From: Anita Gardner
Sent: 16 May 2019 09:44
To: Planning.Responses
Subject: FW: Planning Consultation on LU/109/19/DOC
Attachments: 6239_Shell Petrol Station_Littlehampton_SWM Report_Rev_A.PDF

With reference to our **Application No. LU/109/19/DOC – Shell Eastfield Worthing Road Littlehampton BN17 6LE**, please find attached all documentation and revised plans in line with your comments below:-

Engineers Comments Regarding Condition 3 and 4

Scales @ A1 1:125	Drawing No. 6239-20	Rev A
Status: INFORMATION

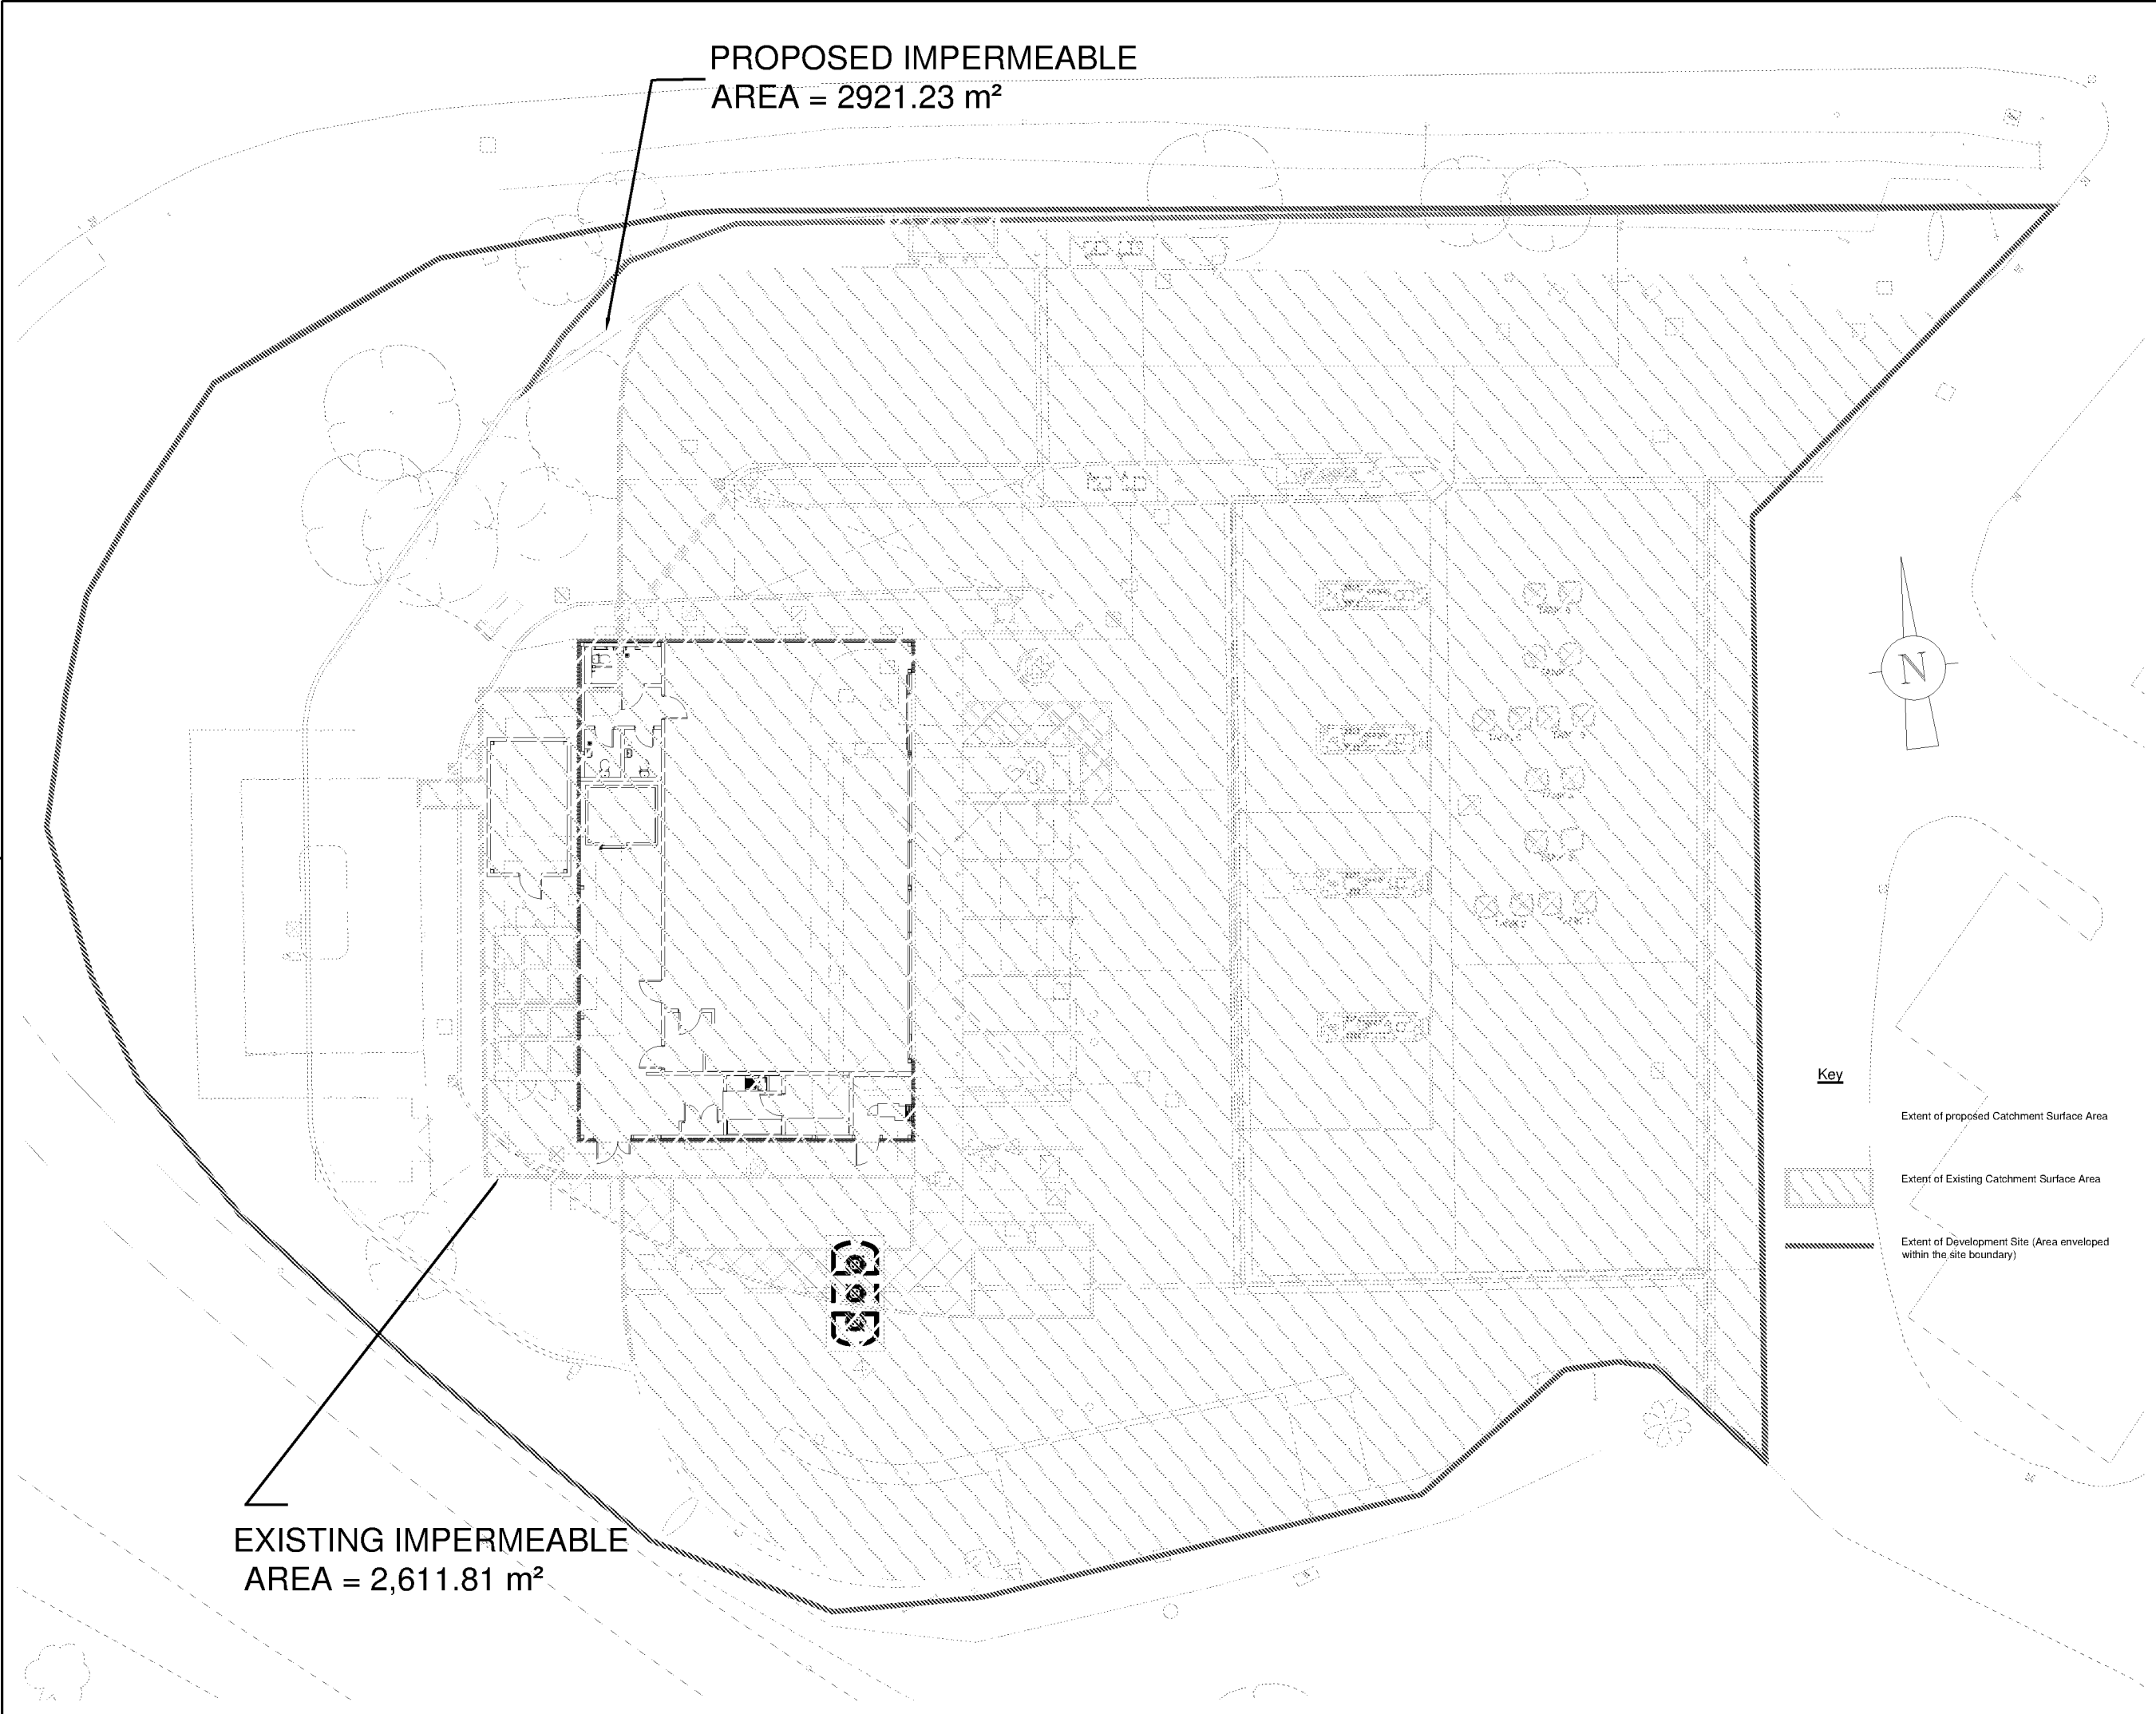
3. The layout plan provided is unclear in terms of differentiation of the two networks. Please revise line types etc.

4. Catchpit manholes should be provided upstream of attenuation tanks.

5. On the layout plan provided everything appears to be ending up discharging to the same location. Yet the text states that the non-contaminated surface water will be discharging to surface water sewer and the contaminated will be discharged to foul sewer. Please confirm and please provide clarity as to whether the proposals are to utilise an existing foul water connection.

Reviewed – Document “6239_Shell Petrol Station_Littlehampton” revised, refer to the revised Drawing No. 6239-20A as per our discussion Tuesday 07/05/2019.

Reviewed – Document “6239_Shell Petrol Station_Littlehampton” revised. Catchpit manholes provided upstream from the attenuation crate systems, refer to the revised Drawing No. 6239-20A as per our discussion Tuesday 07/05/2019.

Reviewed – Document “6239_Shell Petrol Station_Littlehampton” revised. It is only the car wash bay surface water area which shall discharges into the Foul Network through a new oil interceptor. The non and contaminated surface water both shall discharge to an existing surface water connection. The contaminated surface water utilizes the existing system and flow through the existing oil separator prior to discharging to the same existing surface water connection. As discussed, it has been better clarified on the revised Drawing No. 6239-20A – Drainage Strategy.
